Recommendation Report for Planning Permission for Works or Extension to a Dwelling

REF NO: FG/68/19/HH

LOCATION: 4 Elverlands Close
Ferring
BN12 5PL

PROPOSAL: Single storey rear extension to replace existing conservatory and a new dormer window to rear roof slope

PROPOSED ELEVATIONS 1:100@ A2

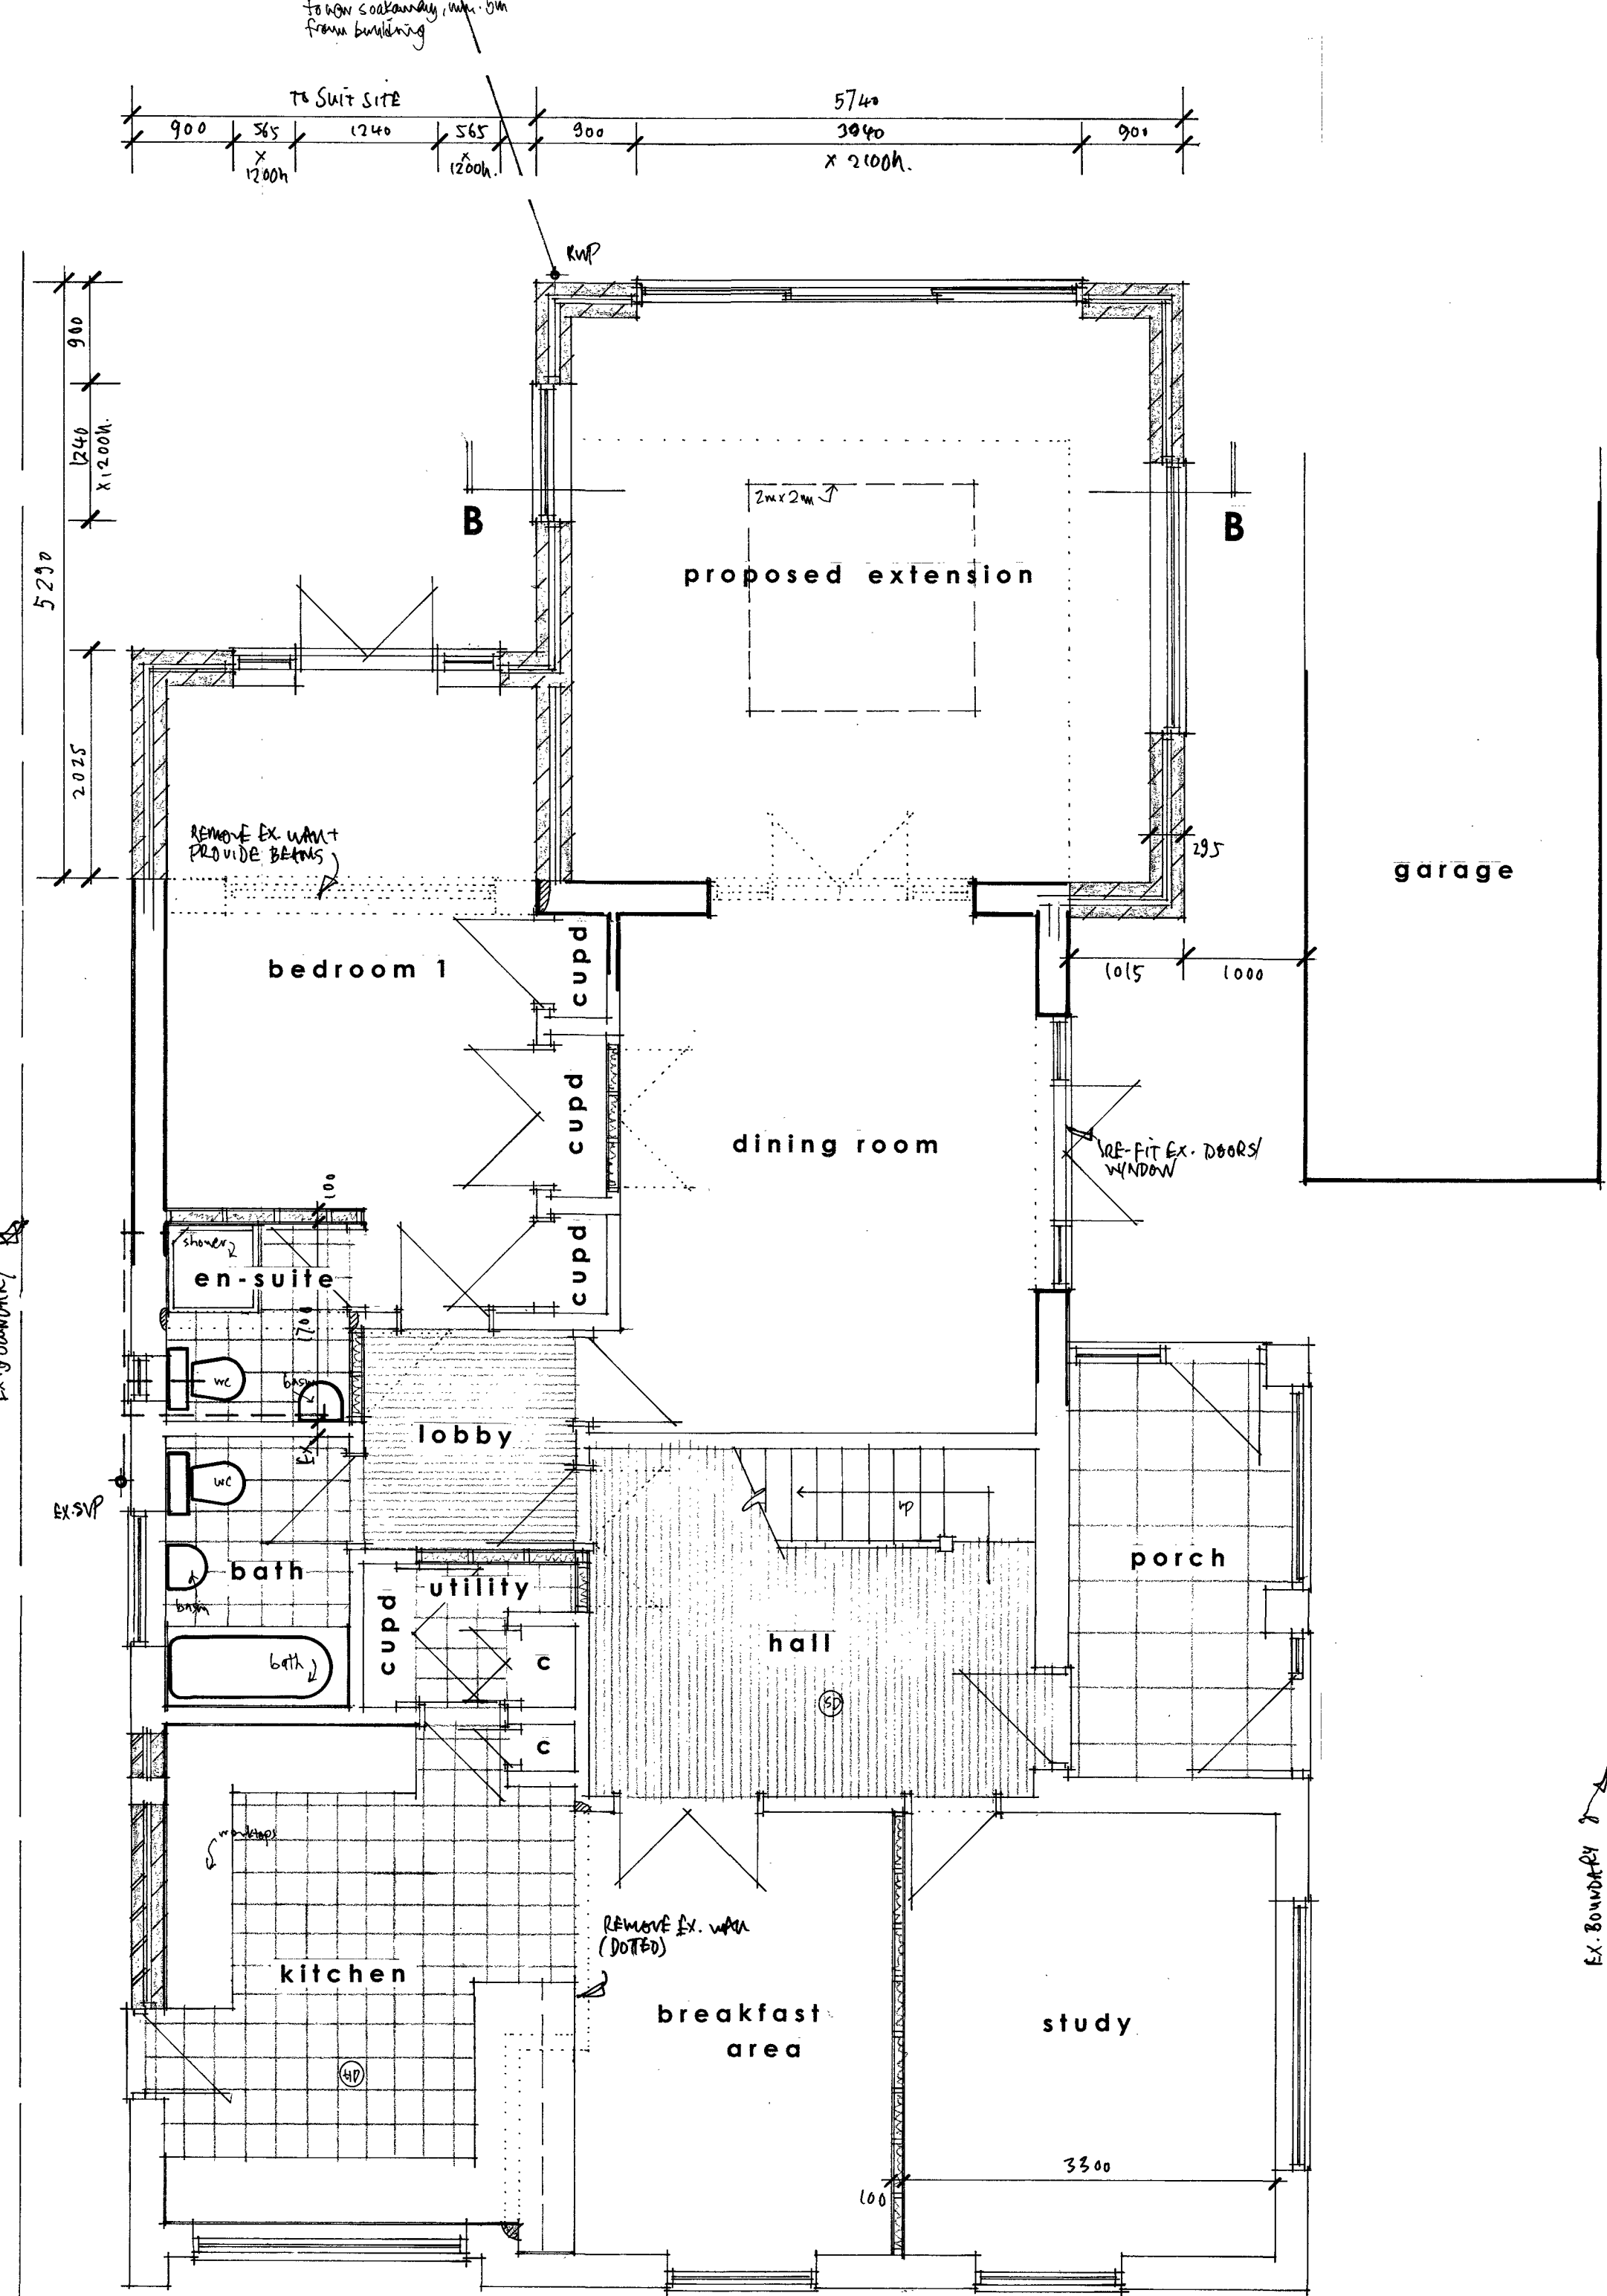
Resultant of its location, the proposed single storey rear extension is not visible from the street scene. It has a maximum roof height of approximately 3m, which is approximately 2.4m lower than the ridge height of the proposed host dwelling (if the development were to be completed). The proposed rear extension is not considered to have any significantly harmful impact upon the character of the host dwelling or its locality. Therefore, the proposed rear and side extensions are considered to be in accordance with D DM1, D DM4(a) and (b) of the Arun Local Plan.

The proposed roof alterations are not considered to have a significantly detrimental impact upon the character of the host dwelling, or the wider locality. It is noted that the proposed development constructs a dormer window that spans the whole width of the roof, and therefore, the roof alterations are not considered to be subservient to the host dwelling. However, due to its design (set in from the sides, below ridge height and sloping side roof), it is sufficiently well integrated with the appearance of the host dwelling. Additionally, there are examples of similar development within the locality, which is considered to allow the proposal to have no significantly harmful impact upon the character of the locality.

Whilst it is considered that the proposed development is in conflict with D DM4(b) of the Arun Local Plan, it is considered that the proposed development is in accordance with D DM1 and D DM4(a) of the Arun Local Plan.

The proposed development is not considered to have any significantly harmful impact on the residential amenities of neighbouring occupiers. This is as a result of its siting and scale allowing no significantly harmful overshadowing of the occupiers of #5 and #3 Elverlands Close. The proposed rear dormer windows provide views into the rear and gardens of neighbouring dwelling. However, the impact on residential amenity is considered acceptable. The bathroom window to the rear needs to be obscure glazed to ensure that the proposal is considered to be acceptable with regards to neighbouring

Reason: For the avoidance of doubt and in the interests of amenity and the environment in accordance with policy D DM1 of the Arun Local Plan.
- 3 The window at first floor level in the on the rear elevation of the building shall at all times be and remain glazed entirely with obscure glass.

- 4 No cladding shall be erected until details of the cladding have been submitted to and approved by the Local Planning Authority.
